**Consultation Response from Alan Smith,
KC Waste Strategy (Refuse & Recycling)**

2026/90507 land adj, 21, Westcliffe Rise, Cleckheaton, BD19 5HX

Discharge of details reserved by conditions 4 (bat and bird boxes), 5 (bins), 6 (Phase II Report), 7-11 (Remediation Strategy), 12 (boundaries) on previous permission 2025/91577 for erection of two semi-detached dwellings

Responding Ref: WPN 26 008

SITE PLAN  
1:250

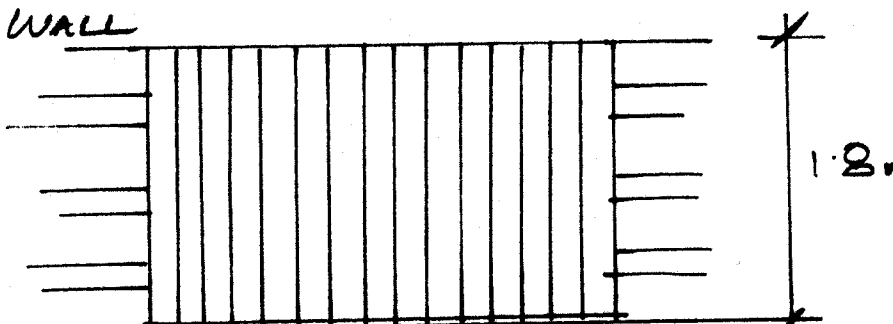
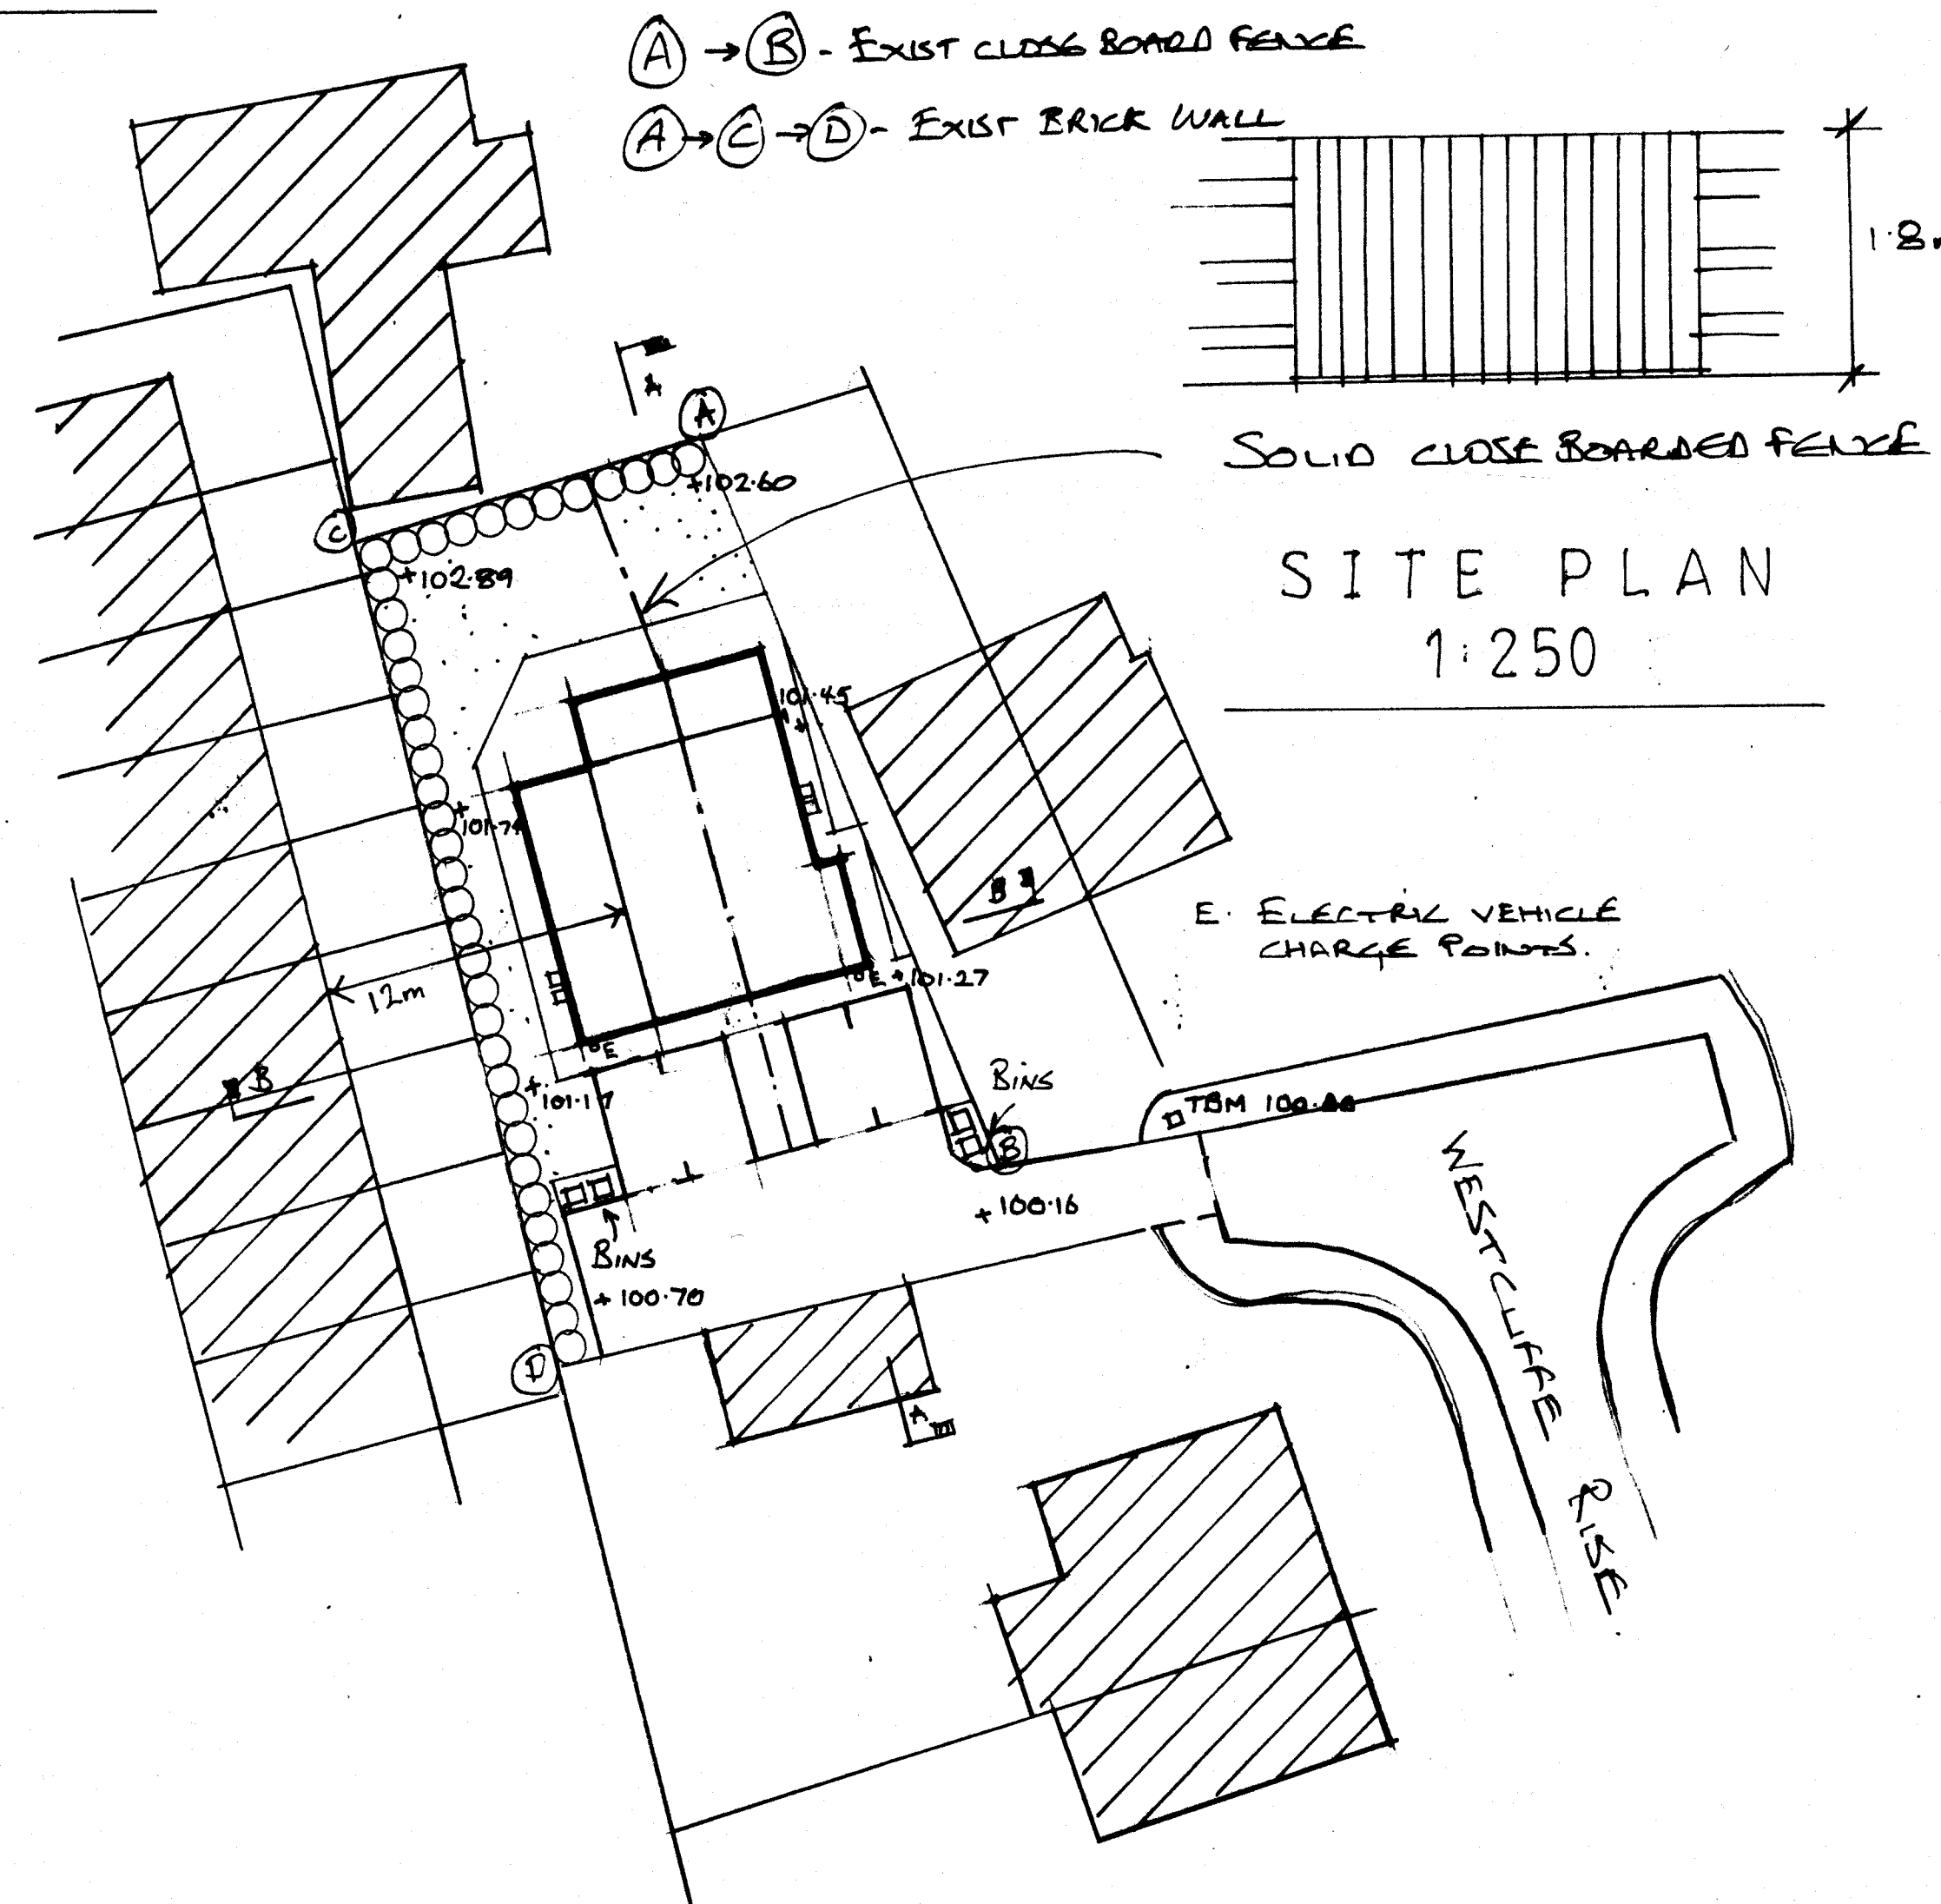
The drawing only shows bin storage capacity for 2 x 240 L bins per property, whereas each property needs room for 3 x 240 L bins. The bins should also be screened and not left adjacent to doors or under windows. In addition, the bin collection point for both properties needs to be shown on the plan, adjacent to the adopted highway.

Given the information provided by the developer the WCA cannot agree to the Discharge of Conditions 5 for the site.
